Our Ref: P/34/26/NMA

Non material amendment following the grant of P/92/25/S73 for VRF units previously shown within the ASHP compound relocated to the south gable with 2.4m high close boarded demountable timber fencing, ASHP units moved 3mt closer to the building (within the approved fencing of the ASHP compound), 450mm Unilog retaining wall shown at the East gable, and Plant Trellis at the East and West gables relocated from the timber cladded facade to the brick cladded facade.

Land North of Hook Lane Pagham

PAPER SIZE	A0	SCALE	1:100	DATE	Sept 24
DRAWING NUMBER	2324-200	REVISION	B

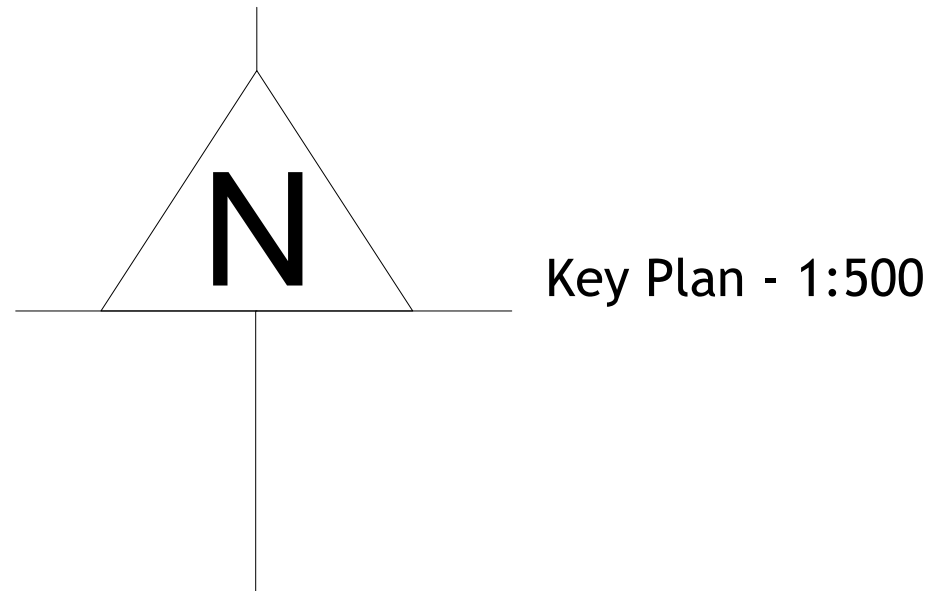
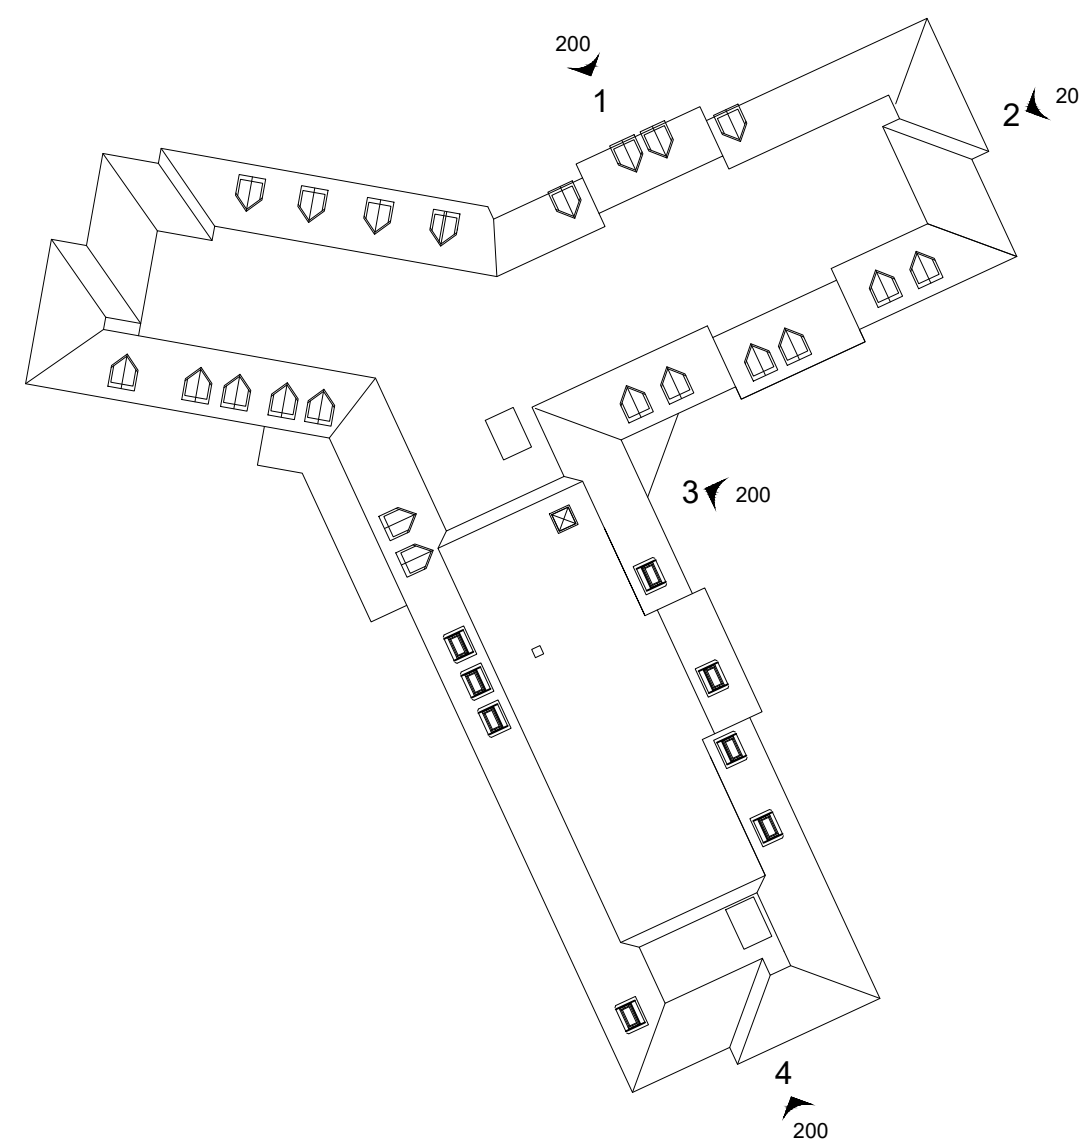
- Relocation of the VRF units to the south gable with 2.4m high close boarded demountable timber fencing.
- ASHP units moved 3m closer to the building (within the ASHP compound).

- 450mm Unilog retaining wall at the east gable.
- Surfacing finish material amended to tarmac.
- Plant trellis at the east and west gables relocated from the timber cladded facade to the brick cladded facade.

The changes outlined above are all acceptable. The proposed drawing revisions have been compared to the approved drawings and are clearly minor alterations that do not conflict with the above guidance or adversely affect the quality of the development as a whole. They will not result in material alterations to the appearance of the Care Home, its surrounding land, nor adversely impact the amenity of nearby occupiers. The changes can therefore be accepted as an NMA under section 96A of the Town and Country Planning Act 1990. The following plans and documents are therefore accepted as a Non-Material amendment:

- Proposed Site Plan 2324_005 Rev I (Excluding reference to the change of surfacing material to tarmac. The materials remain as block paving and resin bound gravel for the footpaths, patios and terraces HL03, HL05, HL06)
- Proposed Ground Floor Plan 2324-100 Rev B
- Proposed Elevations 2324-200 Rev B
- Proposed Elevations 2324-201 Rev B
- ASHP Compound Details 2324_21_514 Rev B
